From: Jeff Weisburg <jeff.weisburg@gmail.com>
Sent: Wednesday, December 4, 2024 7:44 AM
To: PCD Hearings
Subject: File Number VA244, Project Number 191107

I am the land owner of Parcel 5308000074 (7280/7282 Nevada Ln) which abuts parcel 5308000071 (7425 Adventure Way) owned by Woodmen-Utah LLC c/o Vantage Homes Corp.

## Site Plan

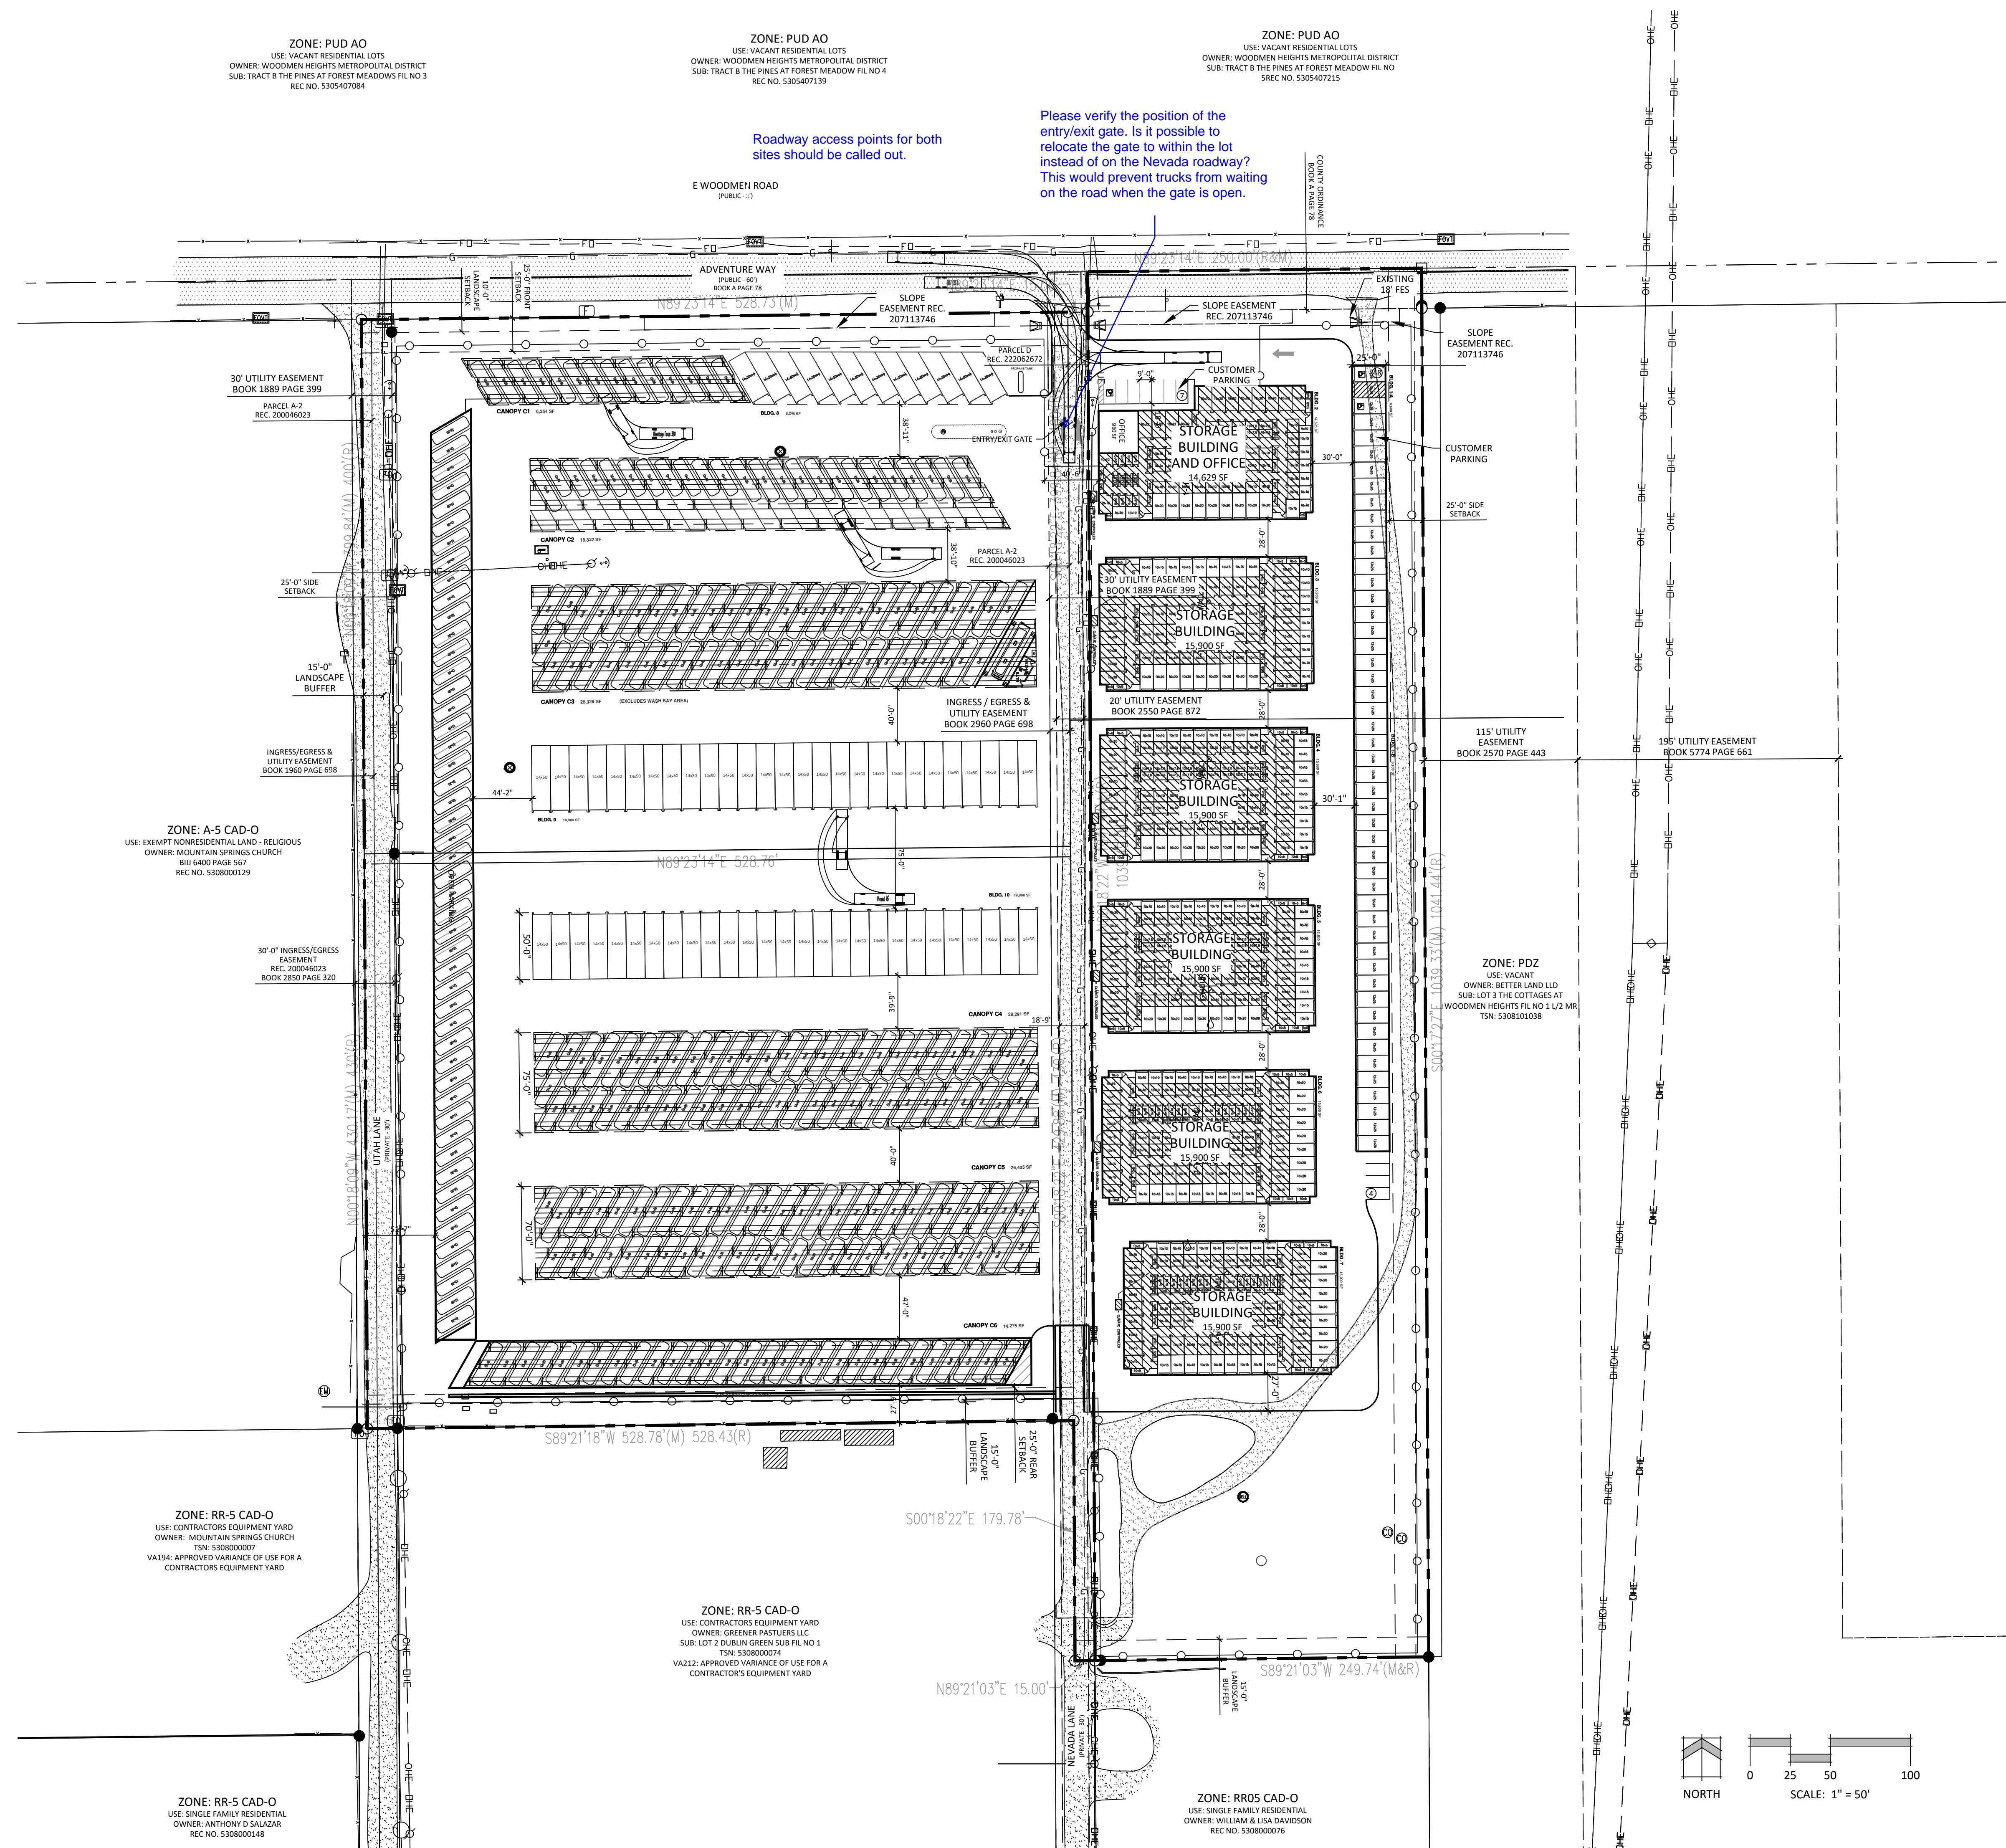
- Due to a significant elevation difference and no preventative grading/drainage infrastructure on their parcel, I have observed storm water flowing from their parcel onto my property for the past 10 years. At times the stormwater runoff has caused consequential erosion along the north side of my property.

- The current location of our gate on Nevada Ln is critical for the flow and ingress/egress of our fenced-in yard. The gate has been in its current location for at least 30 years. Please honor the permanent location of our gate in the Woodmen-Utah LLC (Vantage Homes) site development plan.

- I am generally opposed to the applicant's intention to permanently block and gate Nevada Lane. Until about 2-3 months ago, we have been using Nevada Ln for ingress/egress from Adventure Way without objection or hindrance of any kind since purchasing the property in 2014. It is my understanding that the previous owners, The Hunter family, had used Nevada Ln to access Woodmen Rd without objection or hindrance since the 1950s.
